August 19, 2014

**Re: Imperial Building Grading Plan  
Engineer's Stamp Date 8-7-14 (K14D106)**

Based upon the information provided in your submittal received 8-7-14, the above referenced plan cannot be approved conceptually or for Building Permit.

CG-102

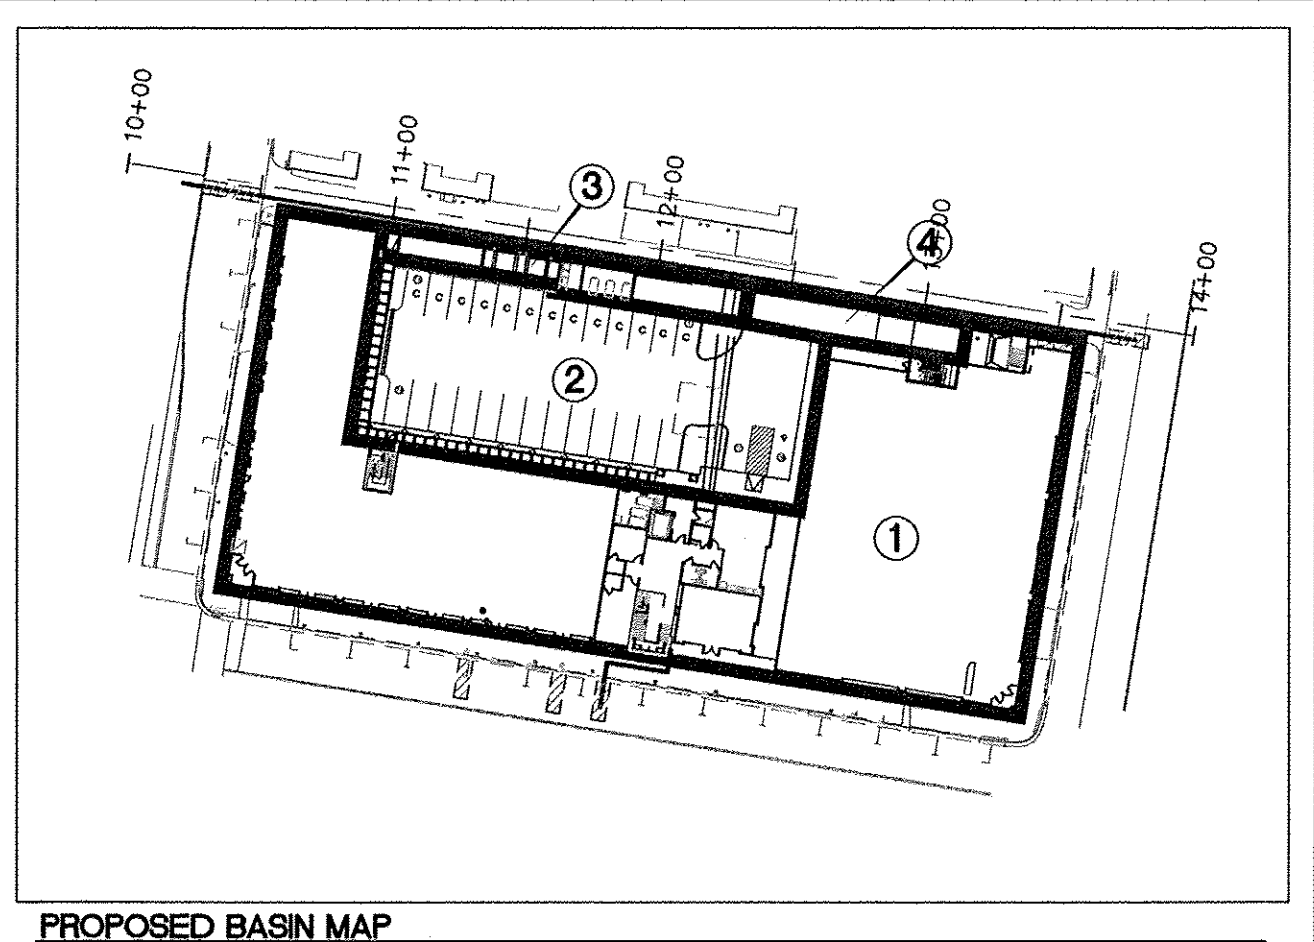
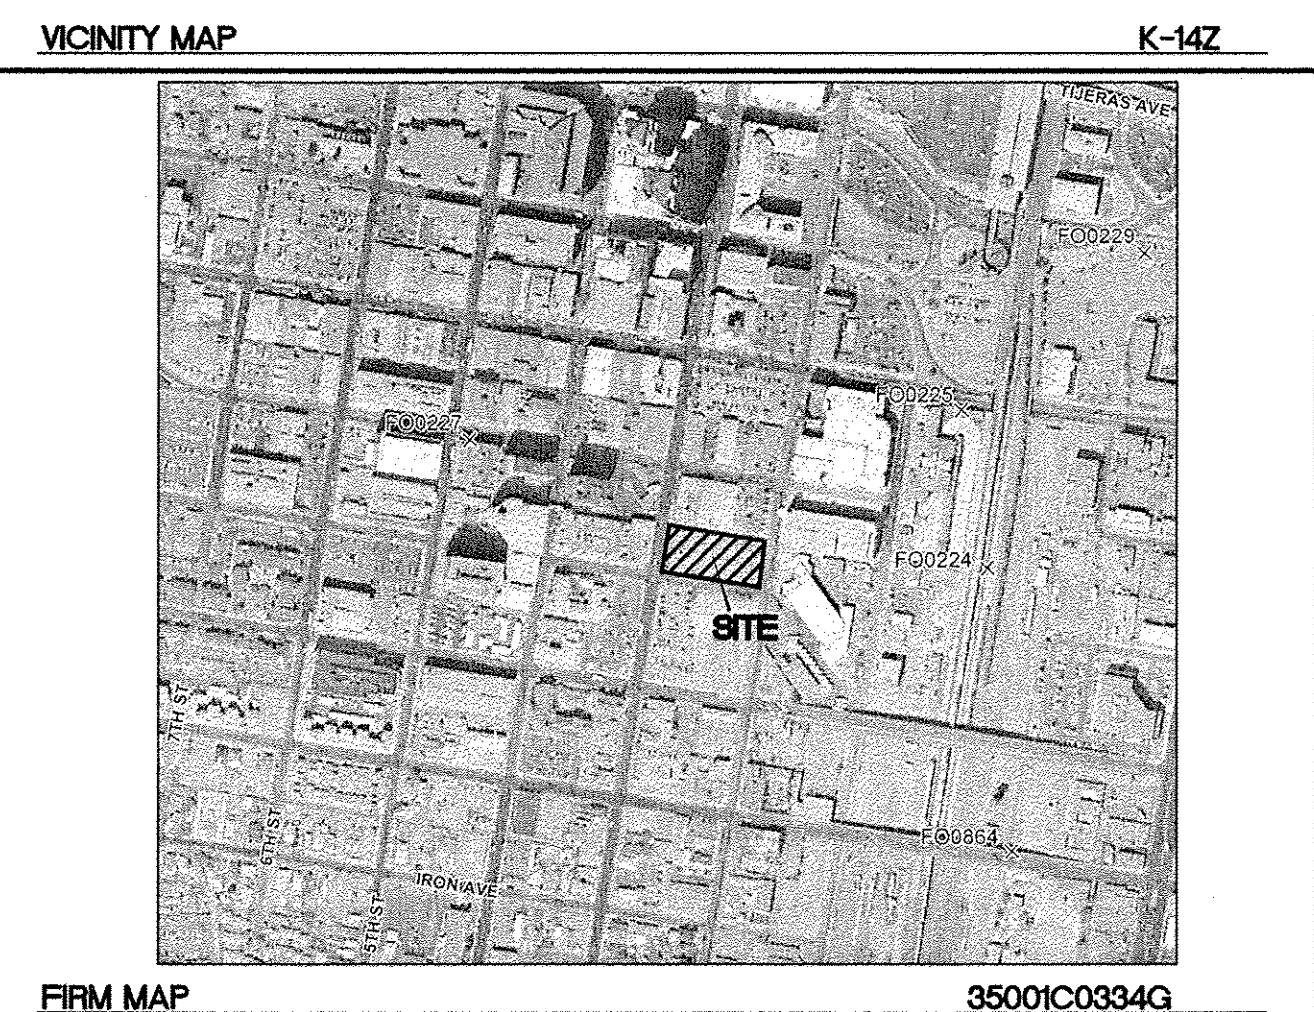
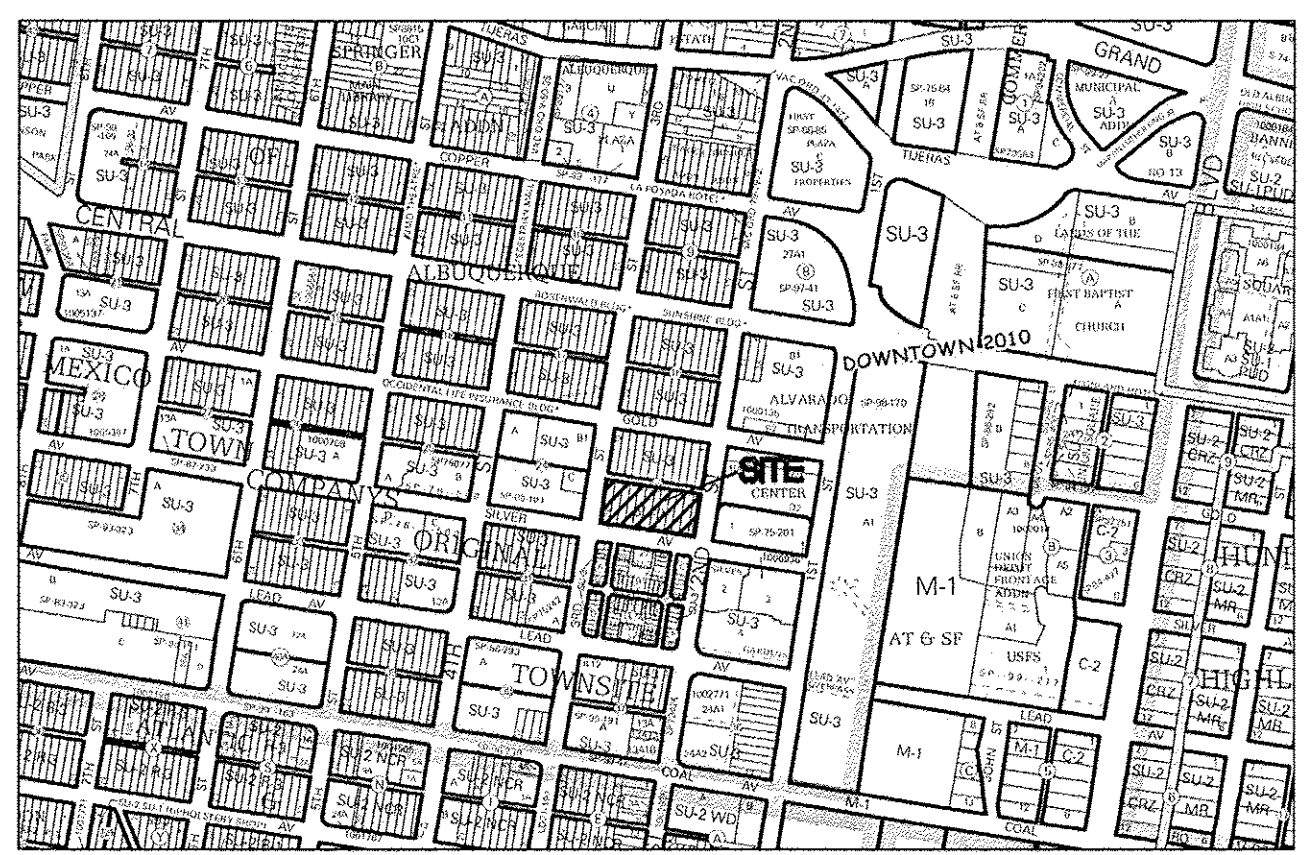
This plan proposes numerous nonstandard designs in the ROW. Since this site is experimenting with LID techniques, Hydrology is proposing that LID strategies used at this site should be at a level that can be ported to other site/streets in town. Therefore, hydrology proposes:

1. The site capture roof flows and build curb cuts around the perimeter for the tree wells. If additional water is required for the trees, it can come from the 34,000 gallon tank.
2. The tree wells contain natural soil and the grade behind the curb is just below flow line in the area of the curb cut with a ponding area in the middle of the well.
3. Grates are built over the wells.
4. An underdrain system is not built.

1. Provide a small water block at the entrance. Is the alley built with an alley section?
2. How does the 34,000 gallon tank overflow in to the inlet when it is lower in elevation?
3. Should the trench drain be connected to the 34,000 gallon tank?
4. Basin 2 produces 16,000 gallons in the 6-hour storm. The proposed tank is 3,500 gallons. Provide the manufacturer's information for the pump and a pond hydrograph to size the tank.
5. Show the roof drains connecting to the 34,000 gallon tank.
6. If the area between the two buildings along Silver Ave is in a building, the interior does not need to be shown.
7. Provide grades at all entrances and in the annulus between the buildings.

8. Unused drive entrances are required to be closed; curb and gutter and sidewalk built. Show locations on the plan with build notes.
9. Provide spot flow line elevations in the gutter around the perimeter. The minimum finished floor elevation is top of curb plus 0.02 times the width of the sidewalk.
10. What does the line work represent along the south and west edges of the parking lot?
11. The plan should be a grading and drainage plan not just a grading plan.
